From: Sarah Kearney <clerkmiddletonstoneypc1@gmail.com>
Sent: 10 March 2023 12:10
To: Planning
Subject: Planning Application - Cala Homes - 23/00214/REM

OBJECTION - WITH COMMENTS

TITLE MIDDLETON STONEY ROAD, MAIN SPINE ROAD JUNCTION. GENERAL ARRANGEMENT SHEET 1	
HYDROCK PROJECT NO. C-27141-C	SCALE @ A2 1 : 500
STATUS DESCRIPTION INFORMATION	STATUS S2
DRAWING NO. (PROJECT CODE-ORIGINATOR-ZONE-LEVEL-TYPE-ROLE-NUMBER) 27141-HYD-XX-XX-DR-D-0001	REVISION P02

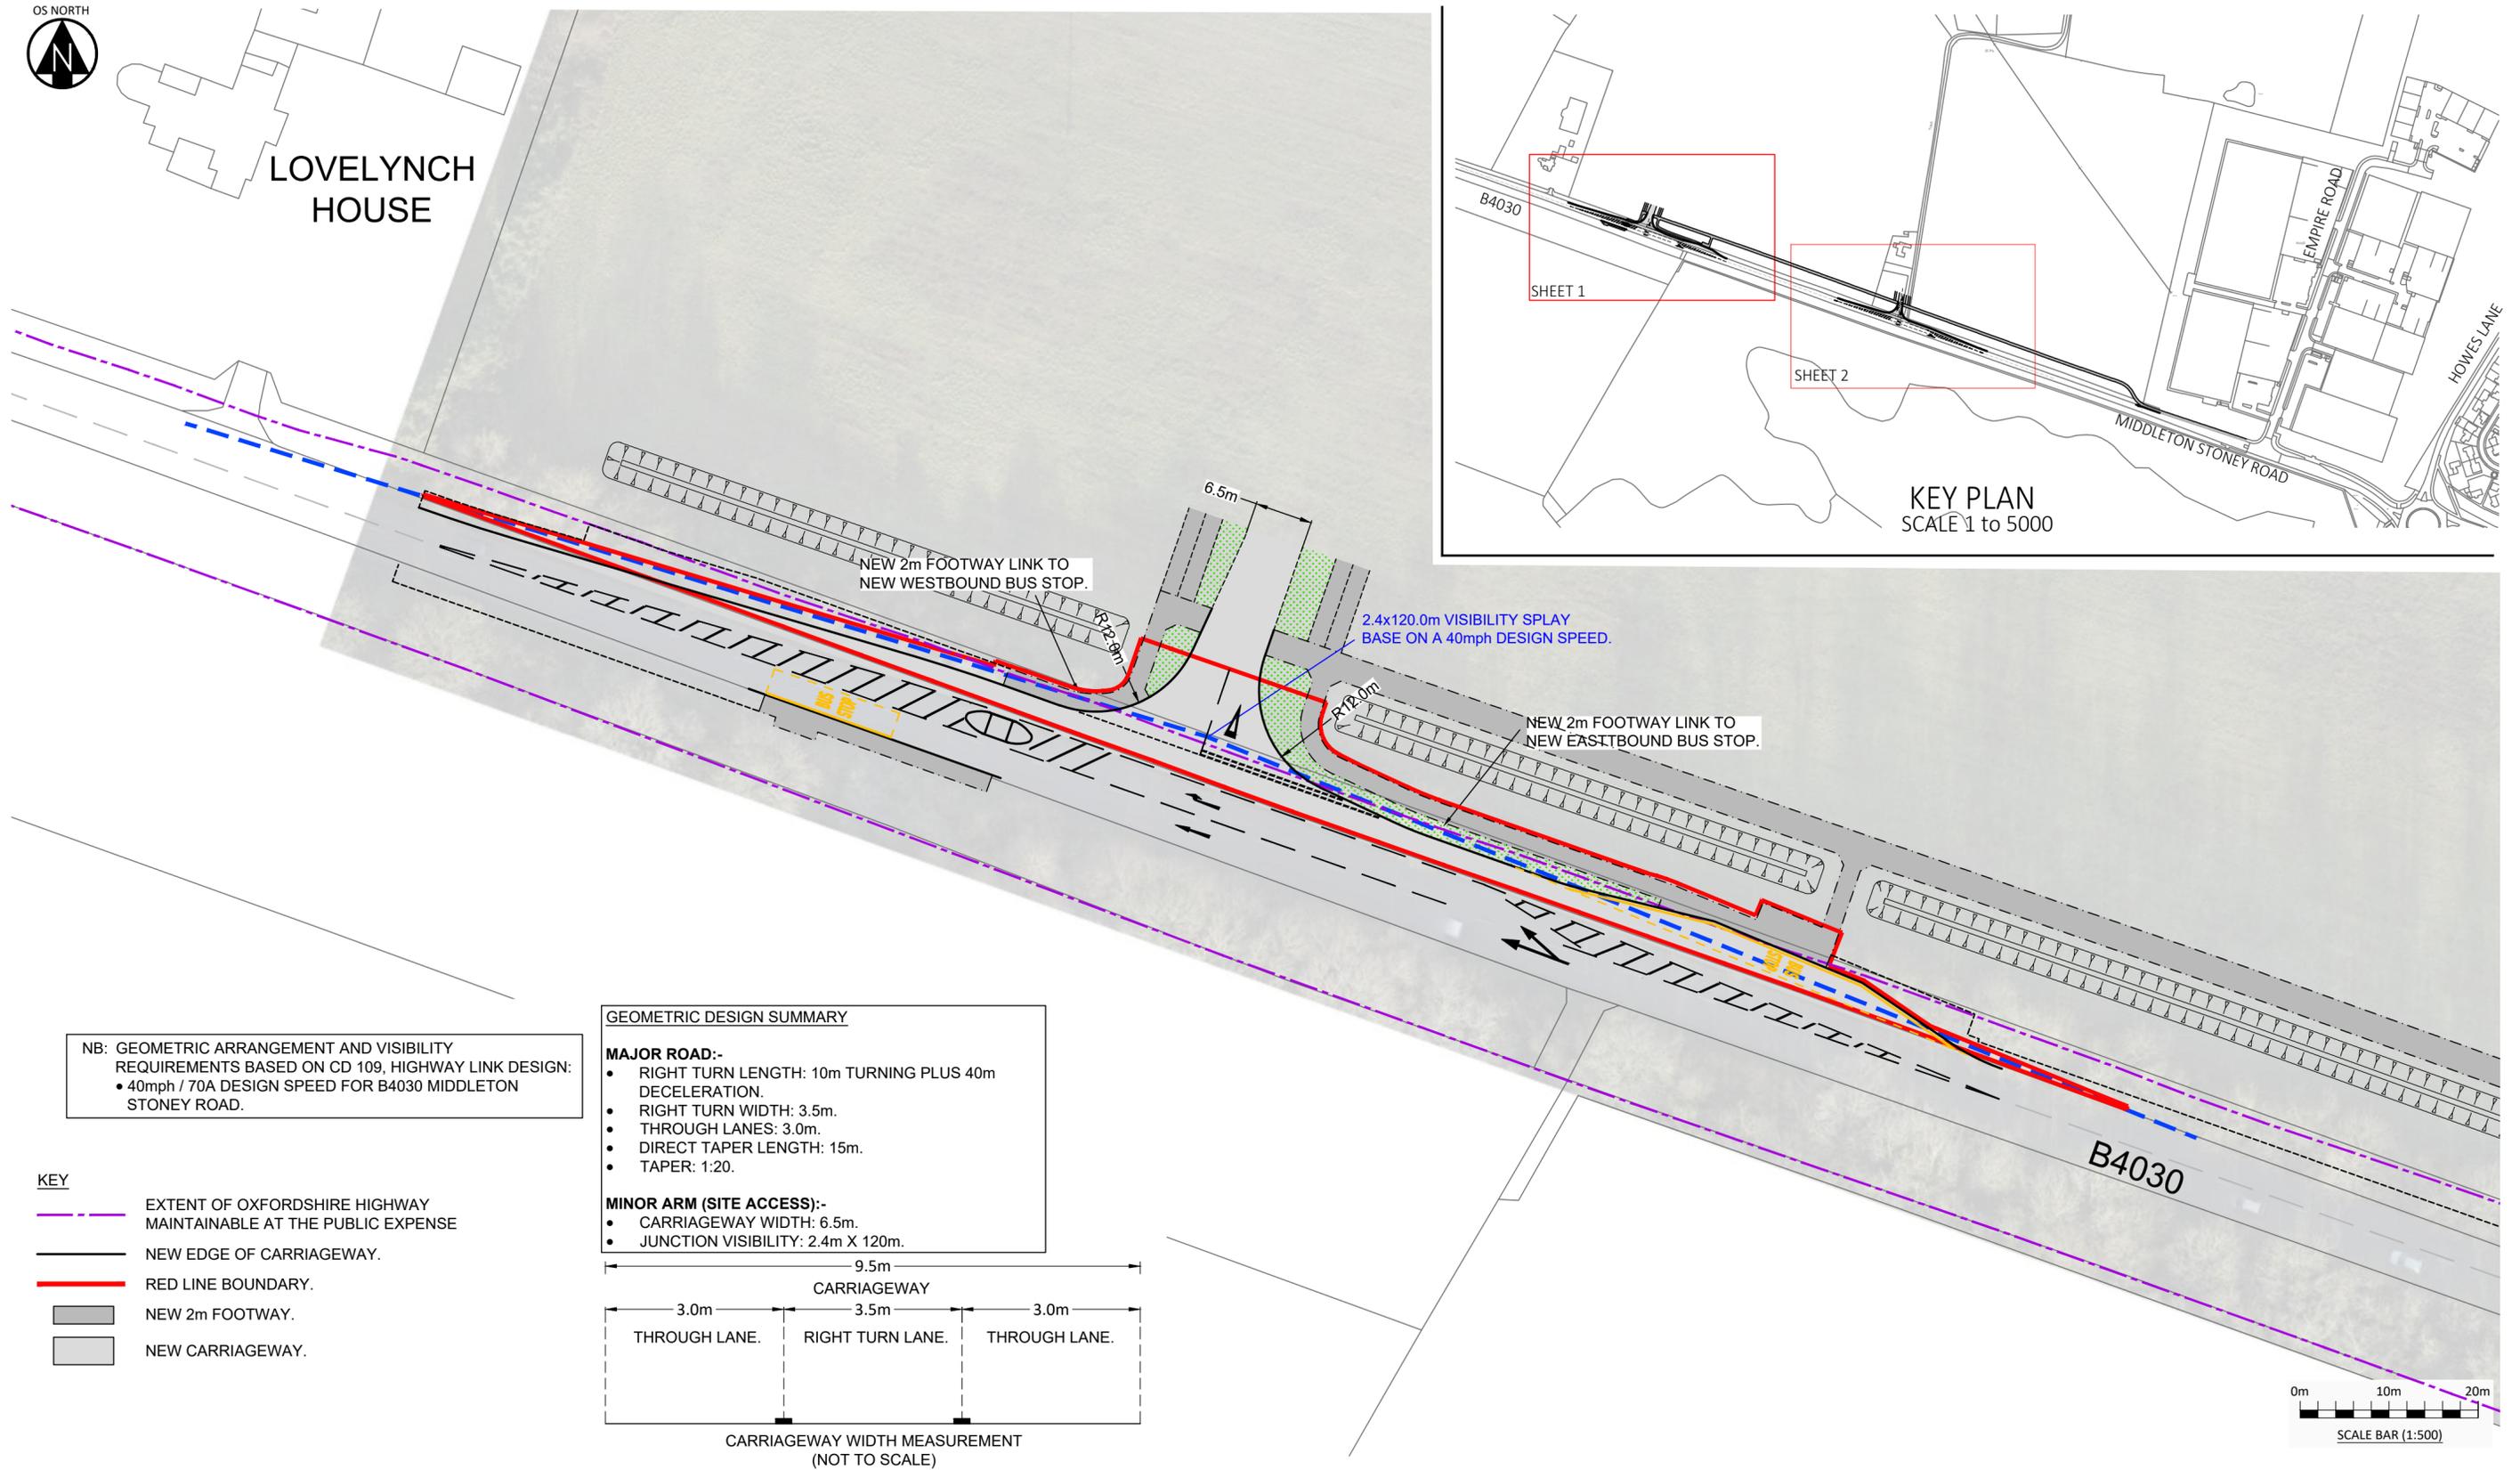
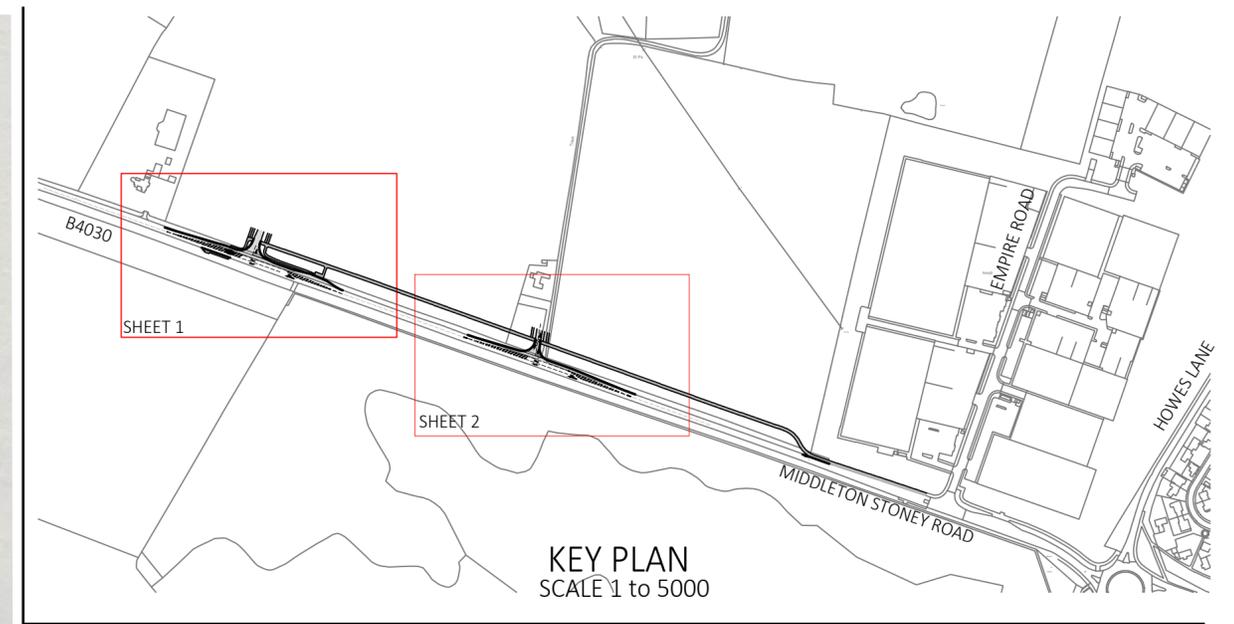
1. Any construction traffic should not come from the west (i.e. from the direction of Middleton Stoney), and there should be a routing agreement to this effect.
2. There is supposed to be both a cycleway and footpath that runs from Middleton Stoney to Bicester eventually which is a part of the Heyford scheme. Middleton Stoney Parish Council would like to see this represented on the plans for the entranceway into Himley Village.
3. The Middleton Stoney crossroads junction (B4030 and B 430) is already significantly above capacity, any approval should be on the basis that all traffic from the new site is not allowed to turn right in the direction of Middleton Stoney.
